Appeal Decision

Appeal Ref: 6010022

18 Canada Street, Barnsley S70 4JZ

- The appeal is made under section 78 of the Town and Country Planning Act 1990 (as amended) against a refusal to grant planning permission.
- The appeal is made by Ms Aleema Sharif against the decision of Barnsley Metropolitan Borough Council.
- The application Ref is 2026/0078.
- The development is described on the planning application form as a 'Proposed domestic garage and summerhouse with ancillary games room/gym over.'

18 CANADA STREET, S70 4JZ

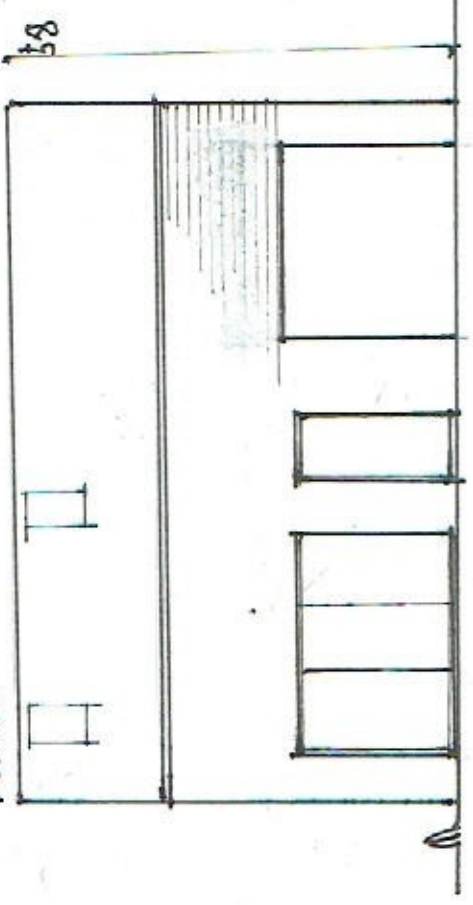
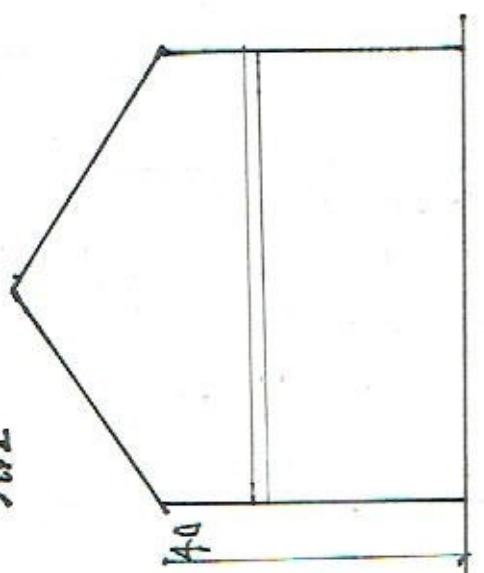
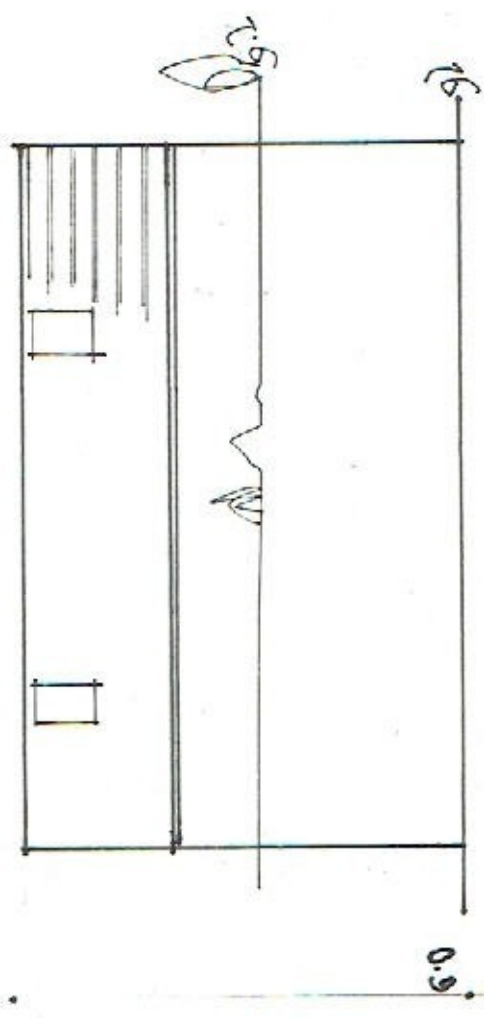
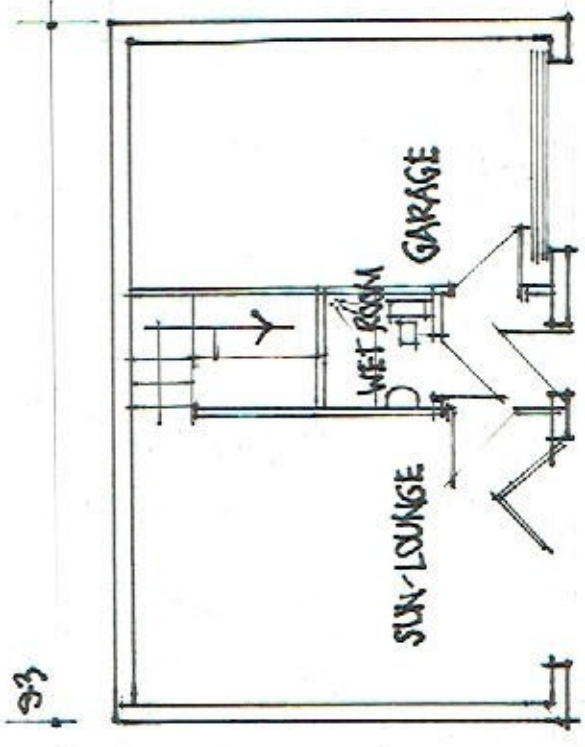
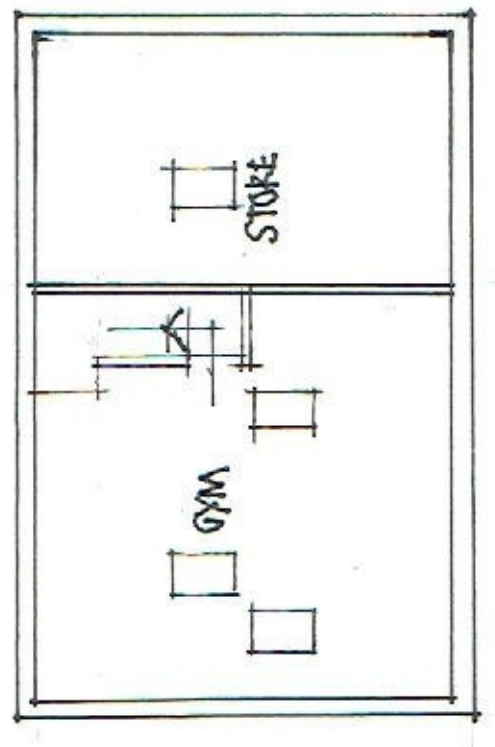
5. The development would introduce a two-storey outbuilding, which would conflict with the advice that garages be single storey, in the House Extensions and Other Domestic Alterations Supplementary Planning Document (2024) (SPD).
Notwithstanding the two-storey scale of the proposal, due to the lower ground level of the rear garden compared to the adjacent properties, as confirmed by the Council, the ridge height may not exceed that of the adjacent garage building at 19 Canada Street. The proposal would be visible from the street scene to the same extent as the rear garages to adjacent properties (Nos 19 and 20 Canada Street).

6. The size of the proposal would also exceed the advised dimensions set out in the SPD. However, from my observations on site, there would remain a sufficient external garden area. Further, due to the topography, ground levels, rear position of the outbuilding, and the existing pattern of rear outbuildings in the vicinity, the proposal would not appear incongruous by reason of its scale and design within the street scene.

9. An interested party has raised concerns regarding overlooking from the rear velux windows and overshadowing of the patio areas of 11 and 12 Columbia Street, that are to the rear of the appeal site. The Council is satisfied that there would be no unacceptable harm to the living conditions of adjoining residents, in terms of the effect on privacy or loss of light. Having regard to the topography I observed on site, I find no reason to conclude otherwise.

7. Overall, notwithstanding there would be some partial conflict with the SPD, I find that the proposal would read as a subservient addition to the rear of the host dwelling in its context which would preserve the character and appearance of the host dwelling and the area.
